RE: THOMAS STREET CAR PARK SITE MODIFICATION 7 OF MP09_0066 (Our ref: S090002)

I refer to your emailed advice dated 16 May 2013 on lodgement by the Meriton Group of a further modification of the approved development on the Thomas Street Car Park site in Chatswood. The approved development in this case means, as indicated in the letter lodged with the application by Meriton Group, the development as approved in Modification 3 of MP09_006 dated 18 February 2013.

Comments on Modification 7

A-0113 F
CONSTRUCTION CERTIFICATE

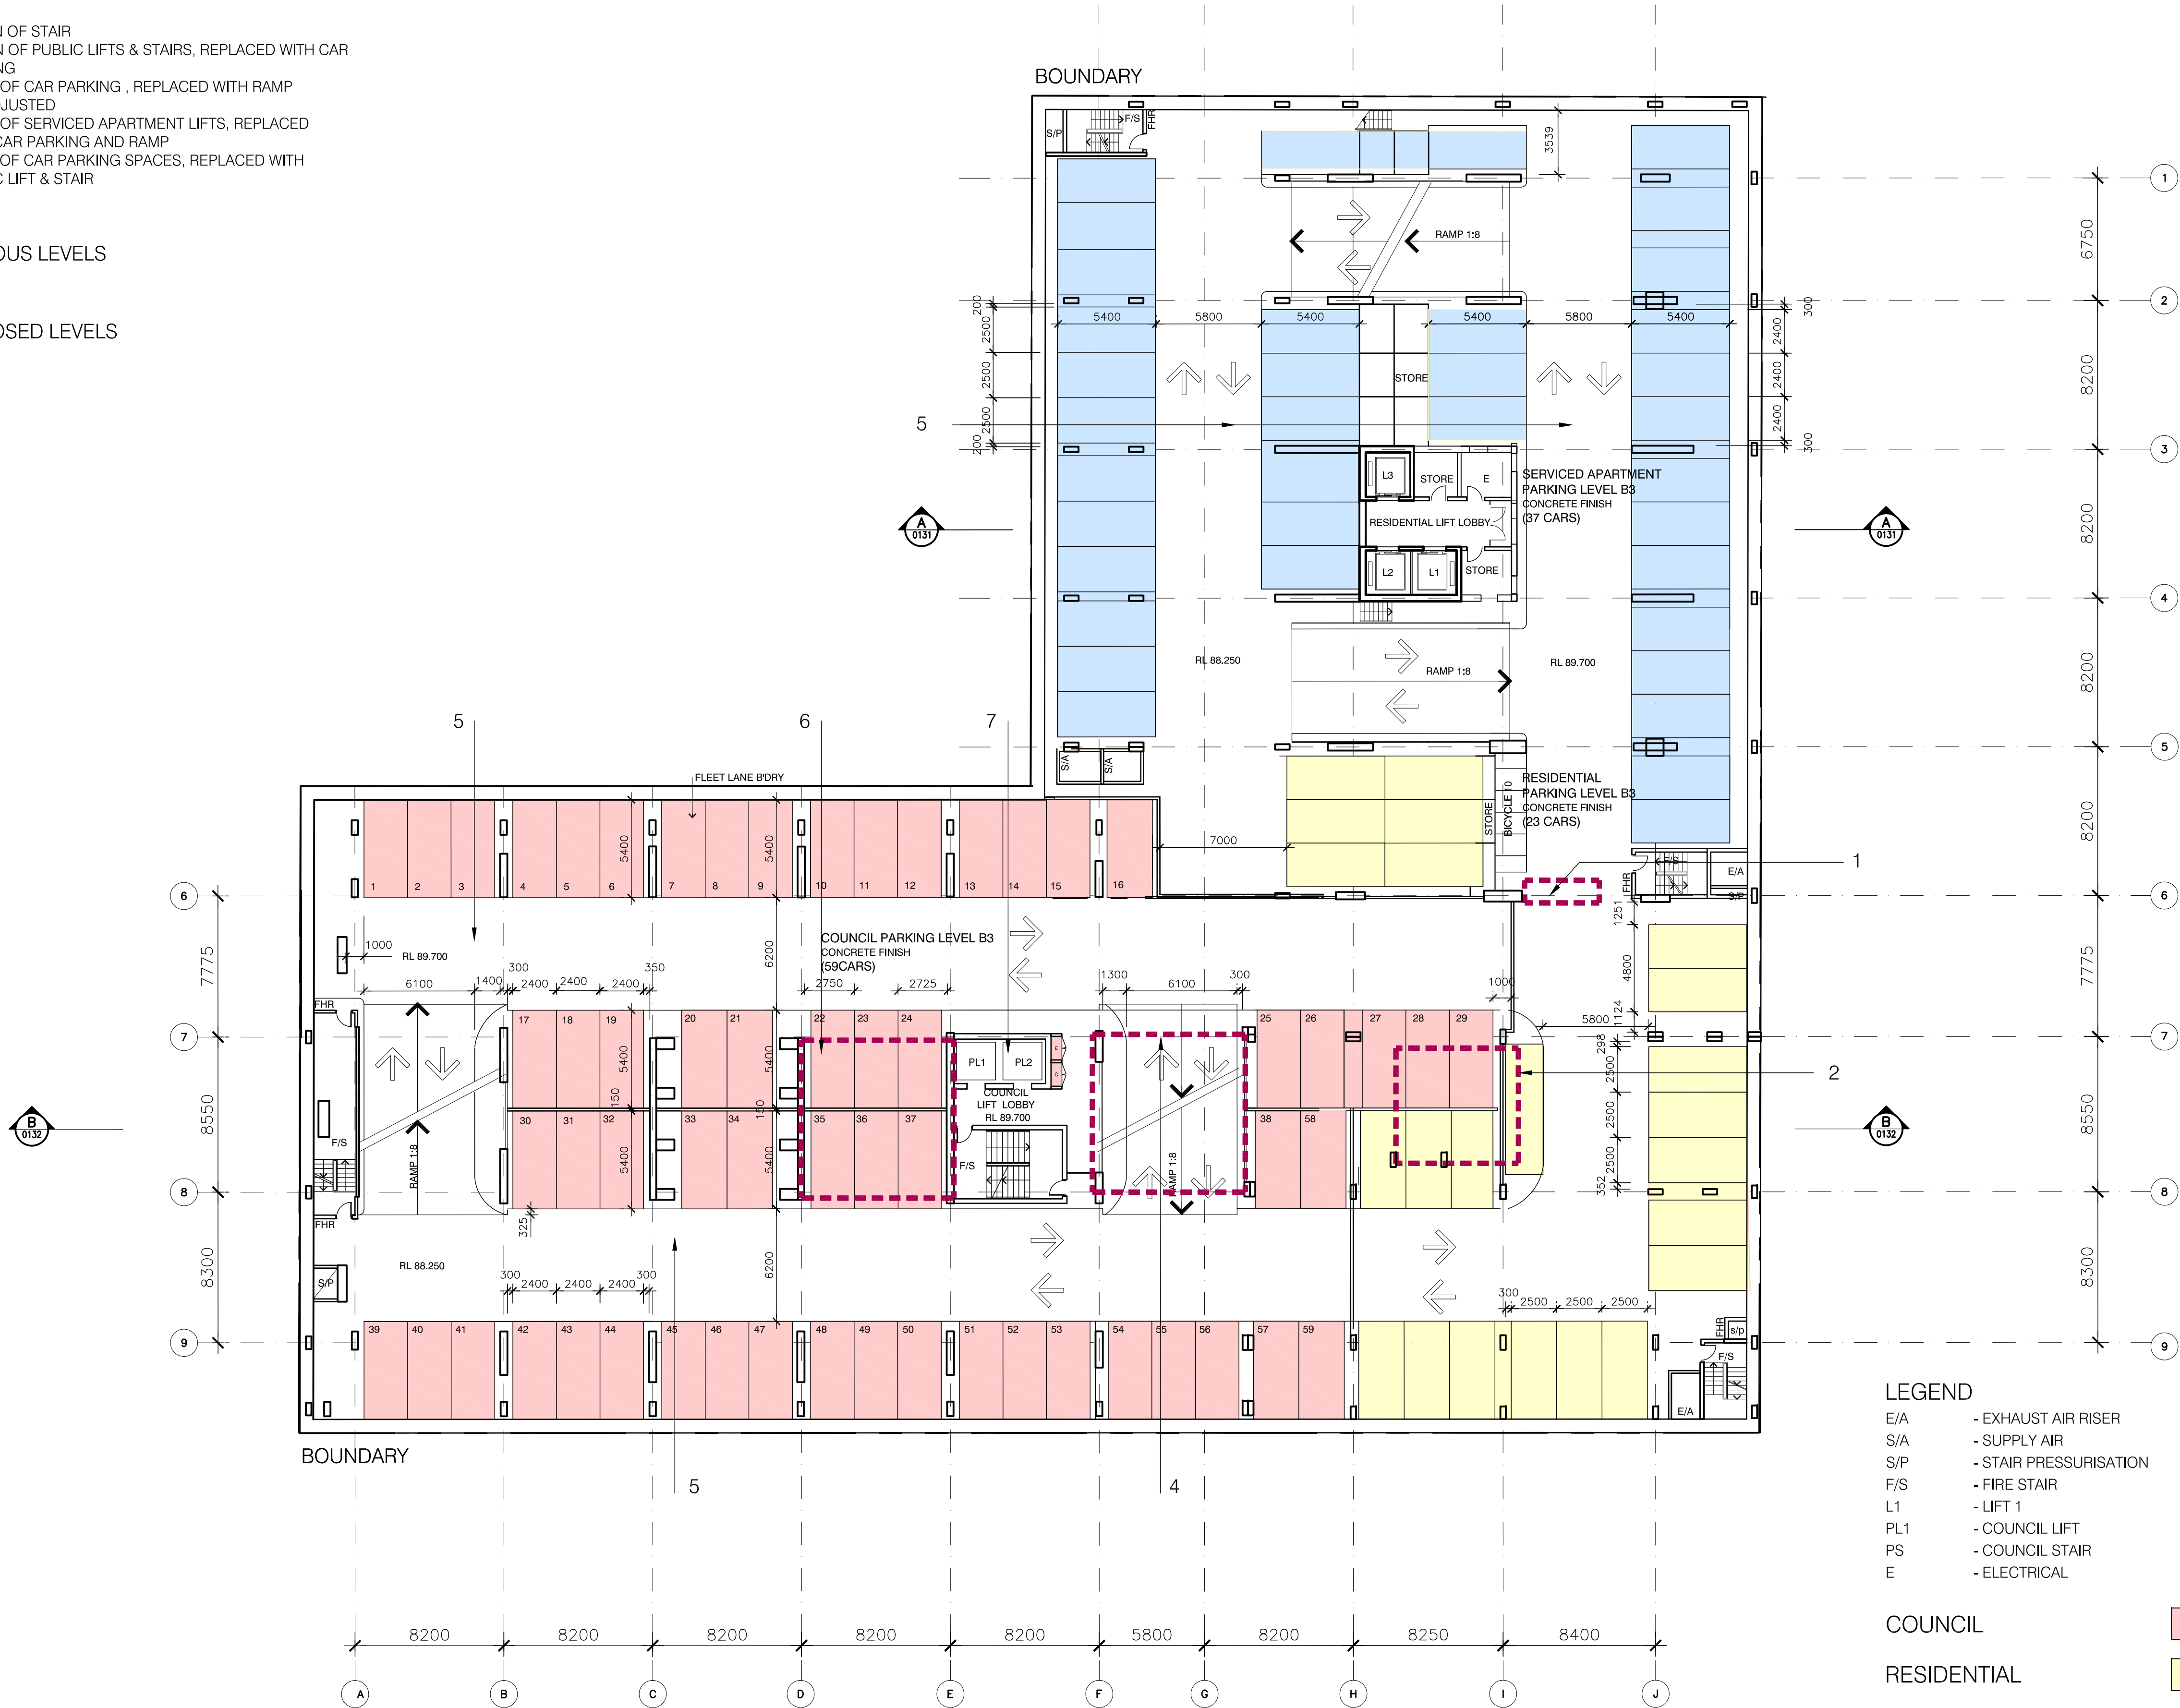
The plans provided go part of the way towards consolidating and separating the public car parking from the car parking for the development on the site. However, as Council has previously advised, the public car parking should be completely separated and accommodated over a minimum number of levels of the basement and occupy the full width of the southern part of the site. The plans submitted still have a lack of separation with the resulting operational consequences in confusion between the public and development car parking. This also has consequences in utility services and separation of the Council owned facility from the operational infrastructure and maintenance of the rest of the development. The Council facility will be separately maintained and operated by Council. The public car park has been repeatedly noted to be a separate land use and entity in the development that is not to be tied to any arrangement involving the residential or serviced apartment components.

A final comment is that the current plans require review as there are inconsistencies in the plans. The residential lift core indicates the provision of three lifts in the tower, three lifts on the ground floor, four lifts on Basement 1 and two lifts servicing Basements 2 to 5. On Basement 1 the slope on the circulating aisle within the public car park has been retained going from RL 96.40 down to RL 94.950. As the floor level of Basement 2 below the location is a constant RL 92.60 this means that the floor to floor level is in part is only 2.35 metres which will not work. The floor to floor level needs to allow for the depth of the concrete floor slab and compliance with Australian Standards for unobstructed clearance in public car parks below the sprinklers, services, directional signage etc.

A-0111 G
SECTION 75 W SUBMISSION

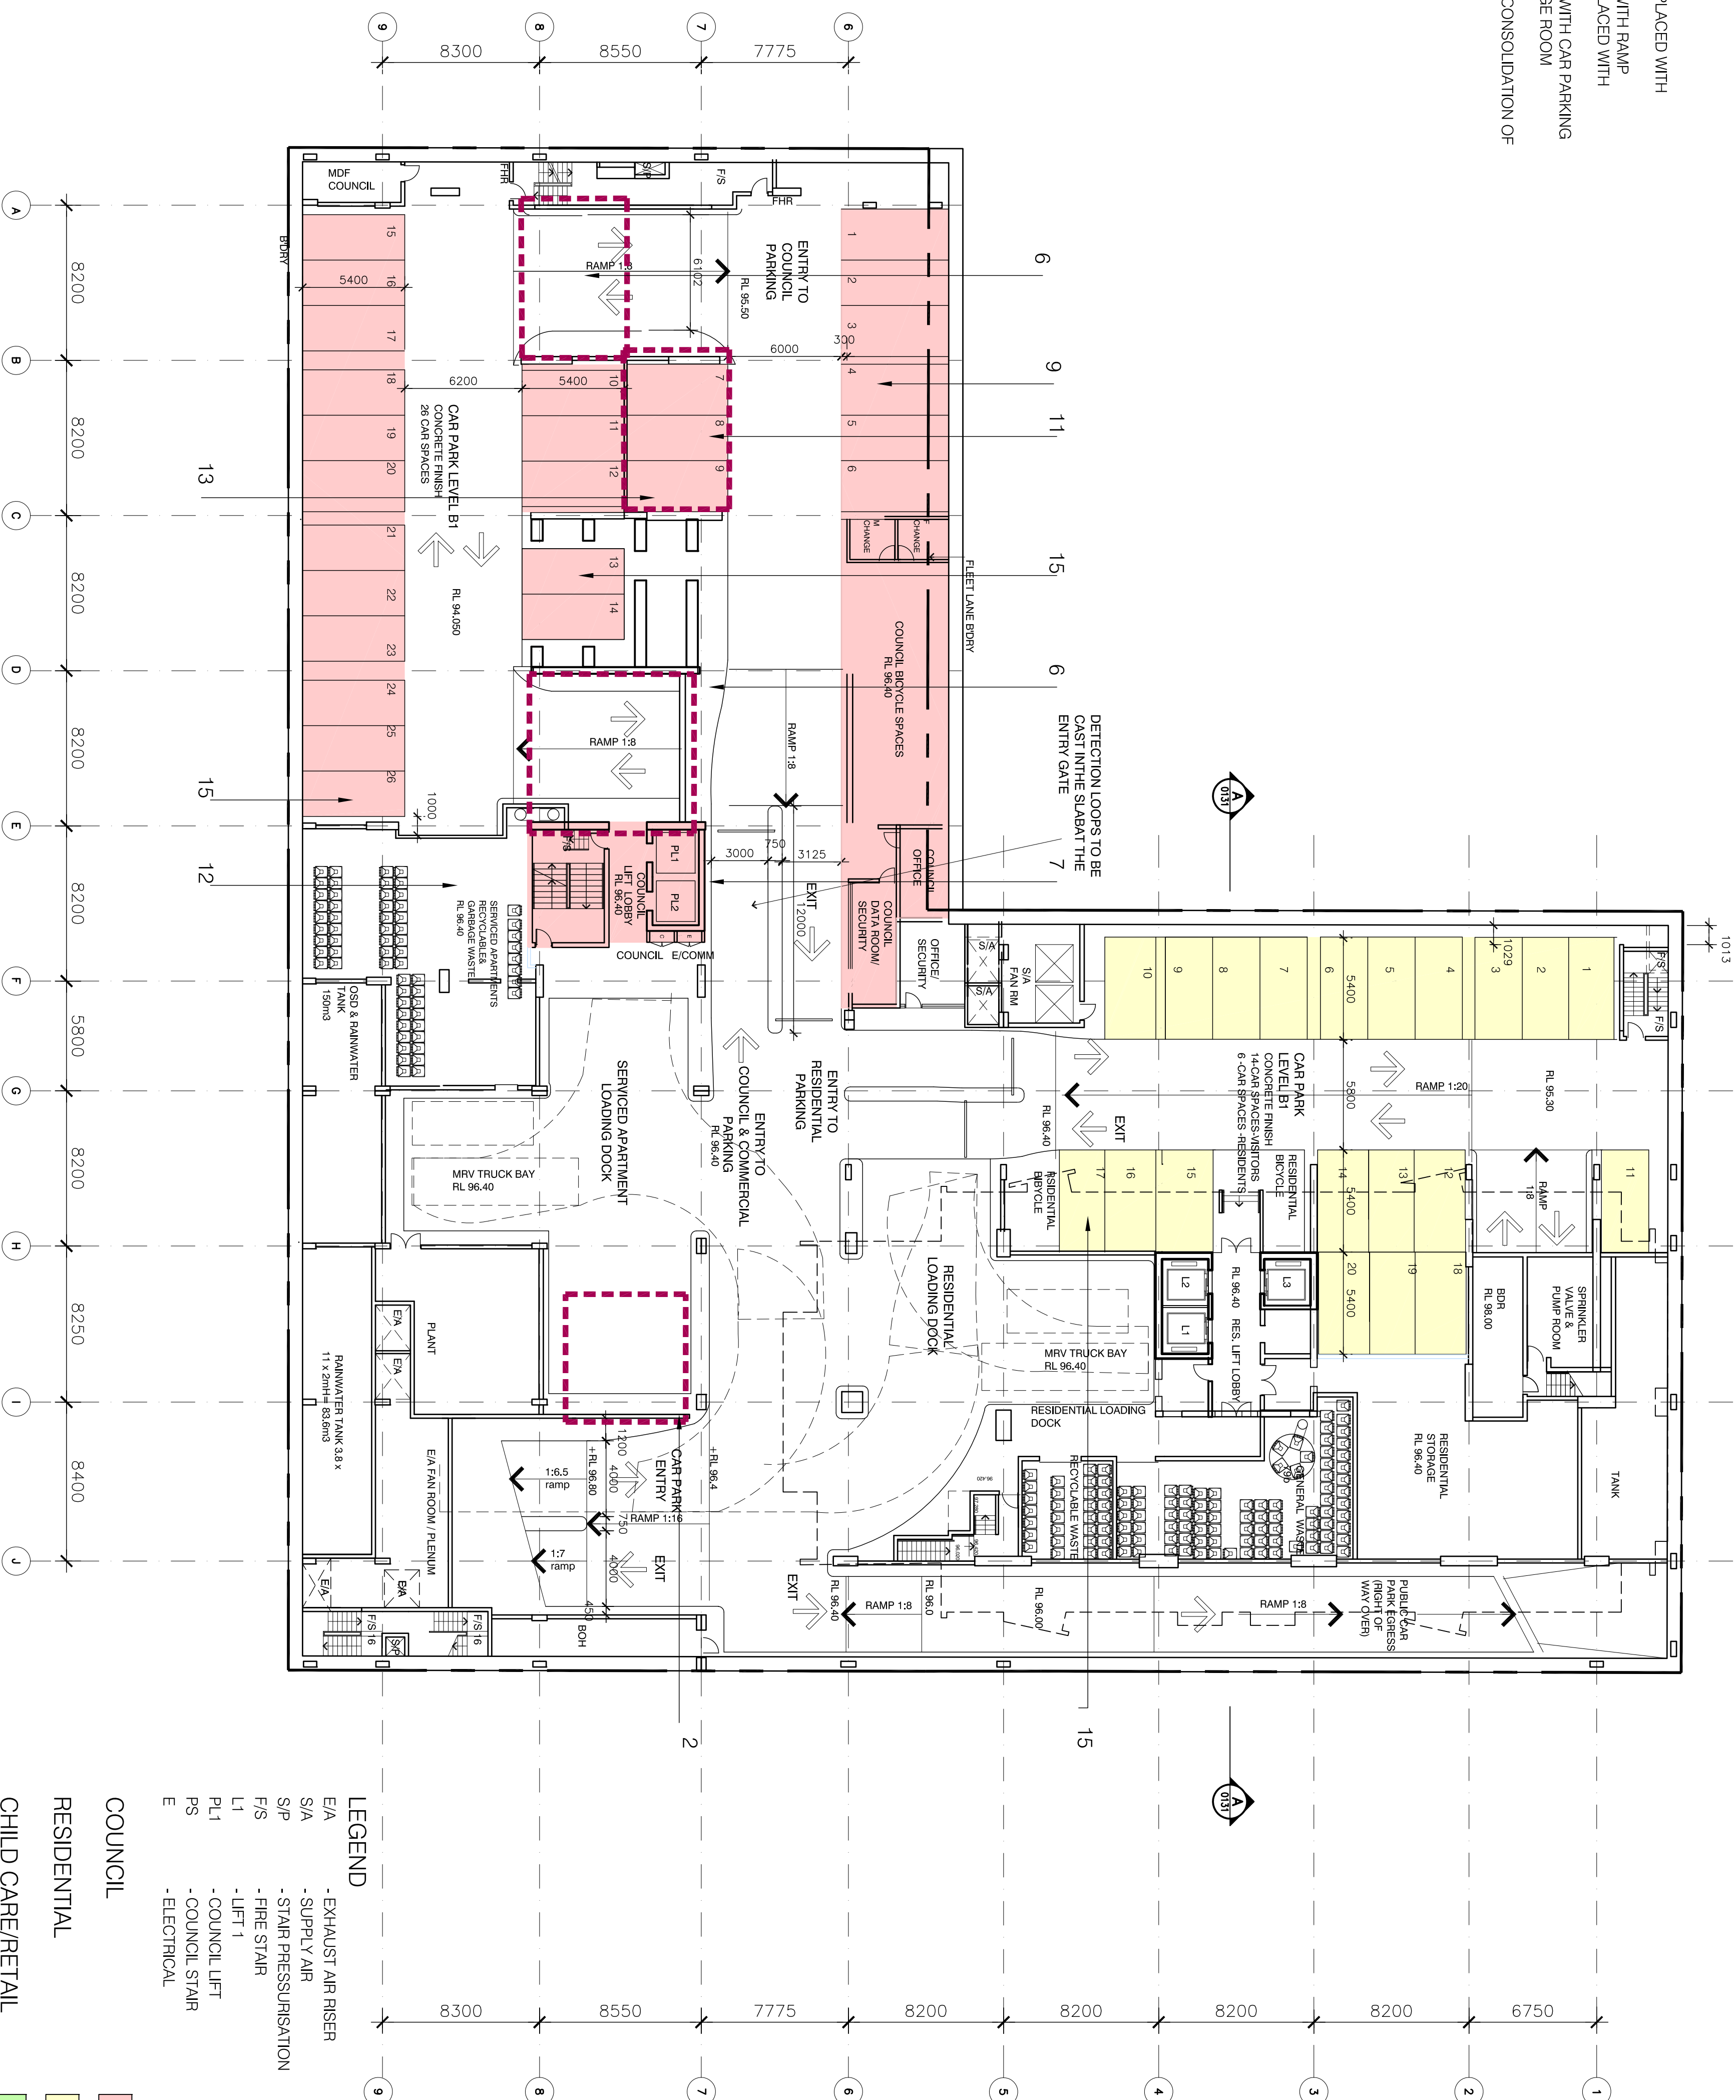
The positive feature of the new design is that the slope in the circulating aisles is being removed (except as noted below) and the location of the Council lift is more central to the public car parking and avoids the need for bike riders and drivers to cross the loading dock on Basement 1 to access the public car park lifts as was approved but objected to Modification 3.
